**WEST SUSSEX COUNTY COUNCIL
STRATEGIC PLANNING CONSULTATION**

DATE: 14 August 2015

SUBJECT: Application for approval of matters reserved by condition imposed under A/167/14/PL relating to conditions 3, 4, 6, 10, 11, 12, 13, 14, 15, 18, 20, 21, 22 & 23 for schedule of materials, tree protection, prevention of surface water drainage on highway, construction of roads, footways/casual parking areas, Travel Plan, archaeological programme, ecological mitigation report, broadband speed, foul water sewerage disposal, surface water drainage, SUDs system, refuse & recycling bins & decentralised & renewable or low carbon energy source.

Former Pound Nursery, Roundstone Lane, Angmering, BN16 4AL

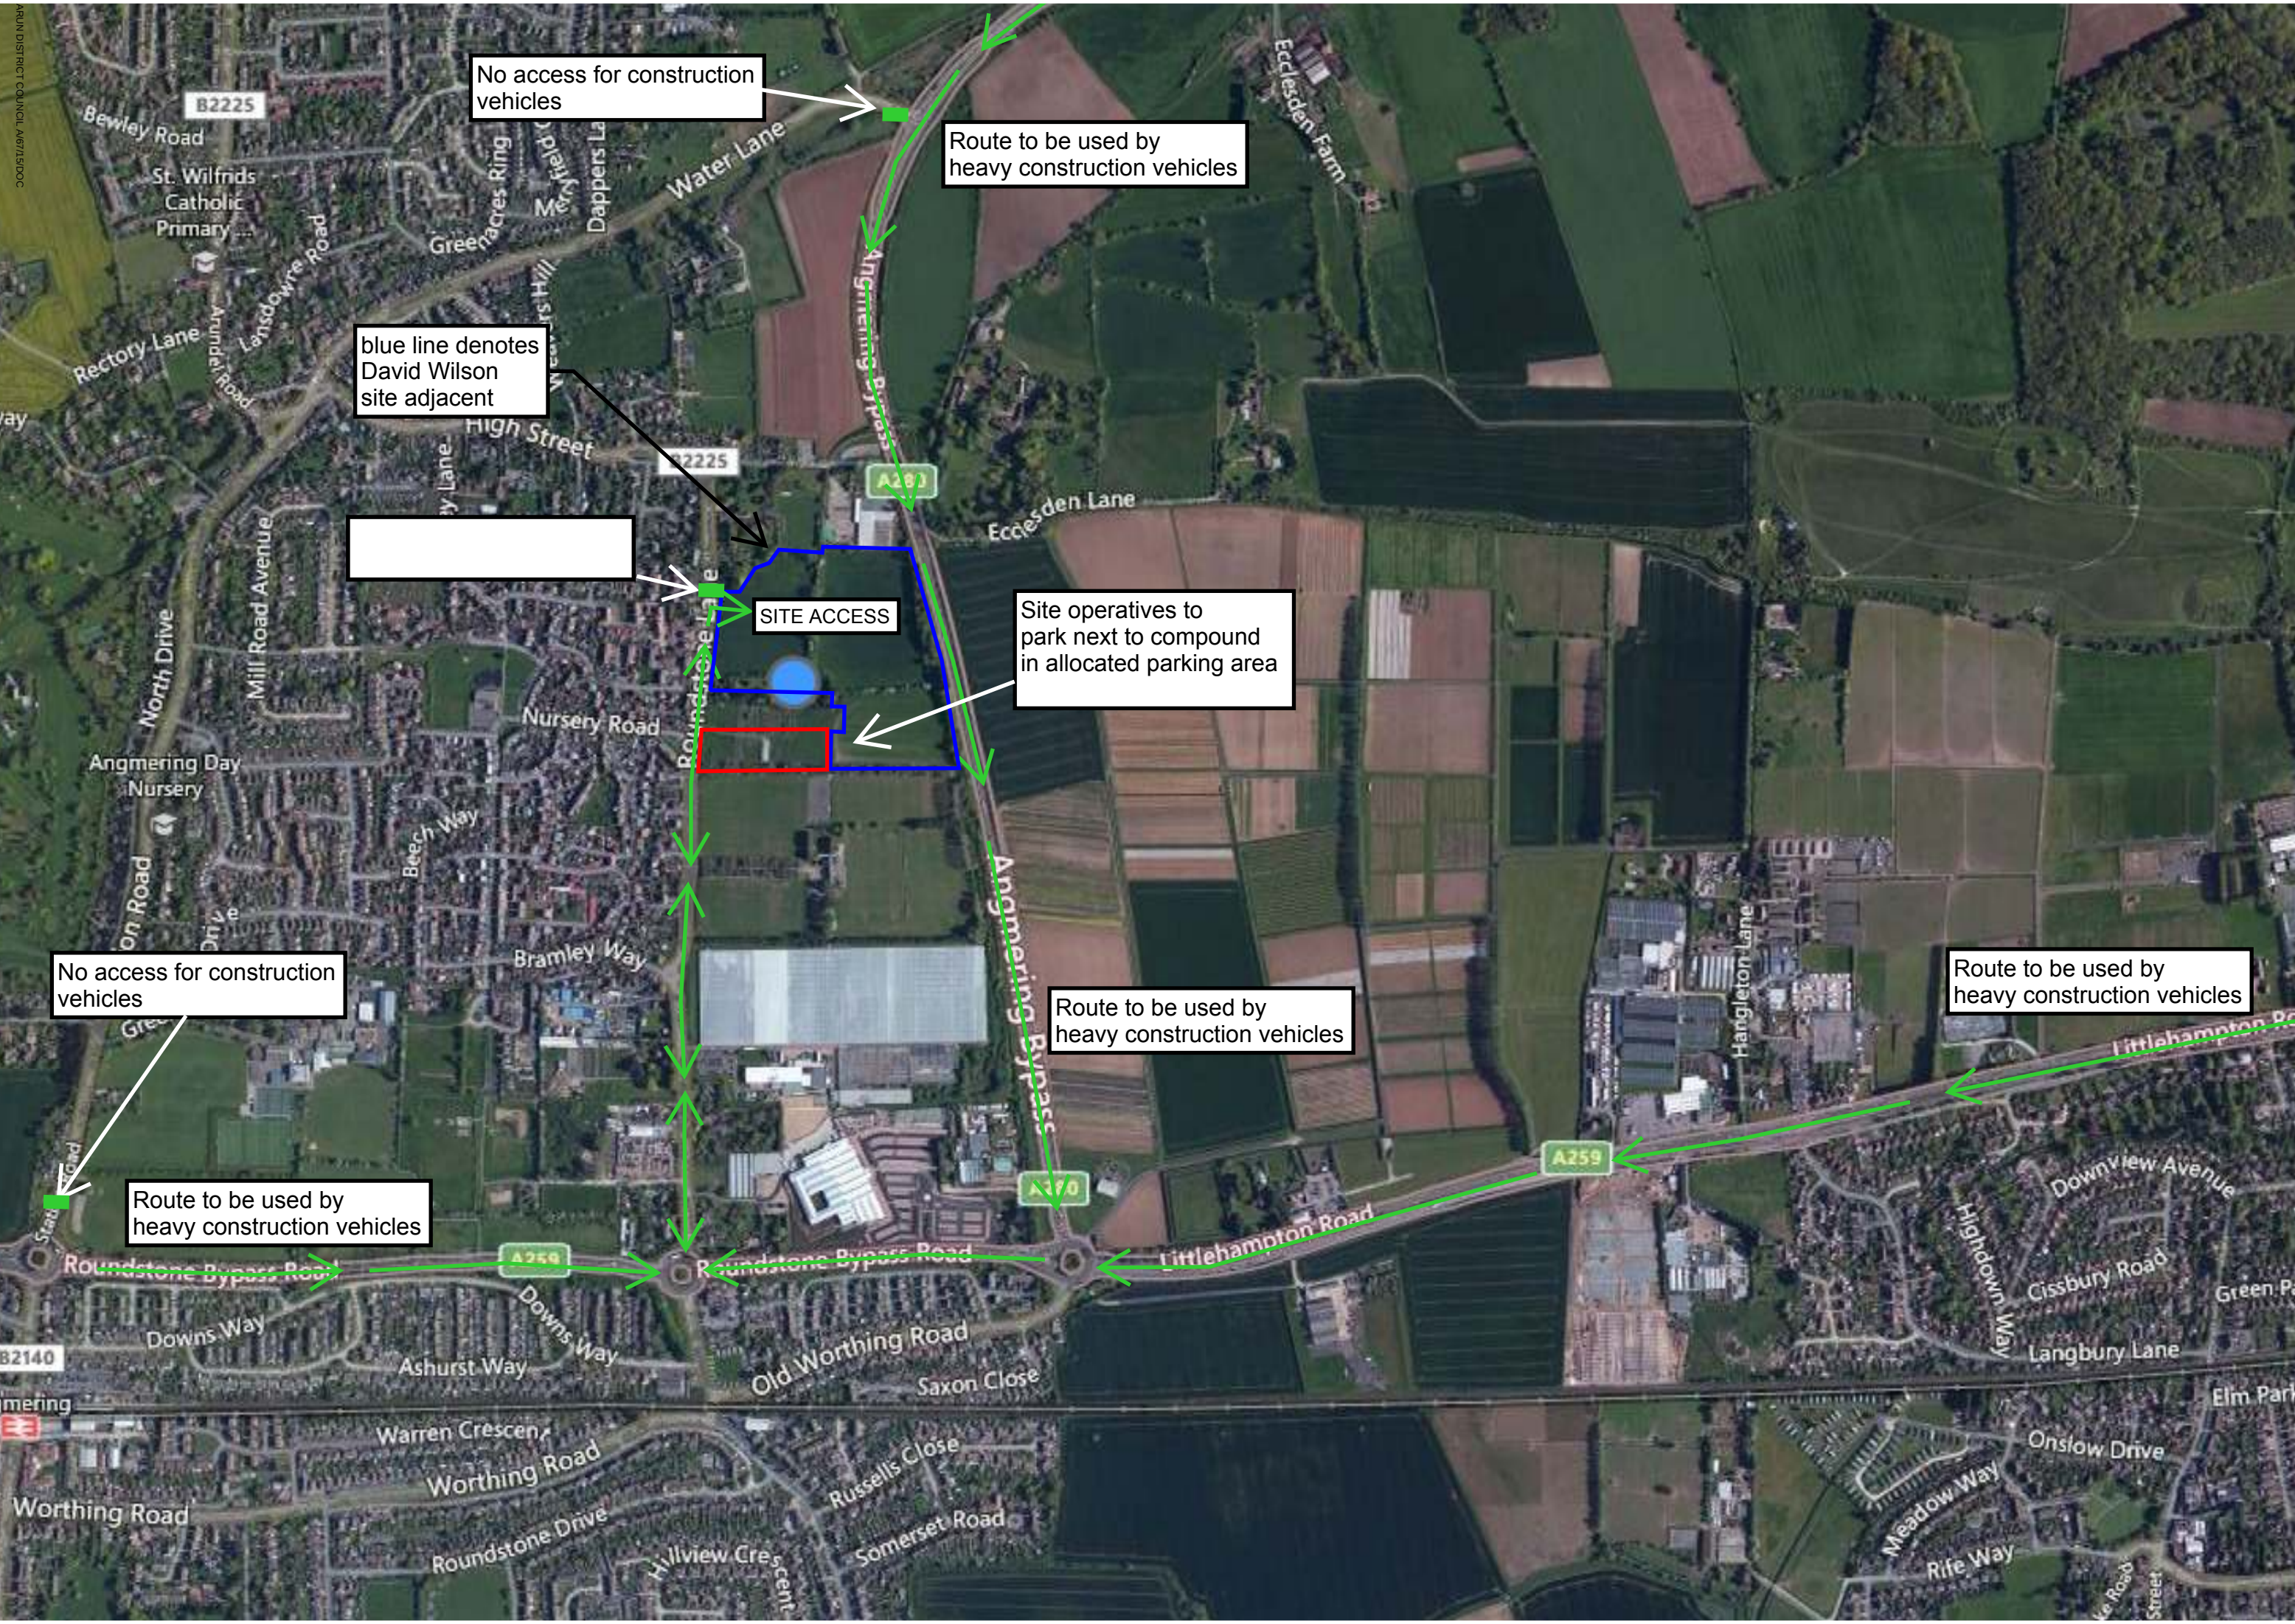
A Construction Method Plan has been submitted, in addition to a plan of the construction area and a vehicle routing plan.

These documents set out that in a daily worst case scenario, 40 cars/vans, 2 forklift trucks, 1 dumper truck and 5 large vehicles will visit the site. All vehicles will be routed via the A259 to the south, with some arriving from the A27 via the A280. There will be no access for construction vehicles to Station Road or the northern part of Roundstone Lane beyond the site access. All vehicles will access the construction site via the adjacent David Wilson site using a temporary construction access, and the impact of the construction traffic upon Angmering village will therefore be limited.

Contractor parking will be provided in the adjacent site, presumably within the parking areas that were contained within the information submitted to discharge the conditions attached to A/82/12.

Materials will be loaded/unloaded within the materials storage areas shown on the plan, with one area within the red line boundary and another within the adjacent David Wilson development site. The hours of work on-site have been confirmed as 0800-1700 Monday to Friday, 0800-1300 Saturday and no Sunday working.

The whole site is to be secured with Herras fencing and wheel washing facilities will be shared with the adjacent site, which are situated at each entrance. This will prevent mud and dust from being transferred onto the public highway.
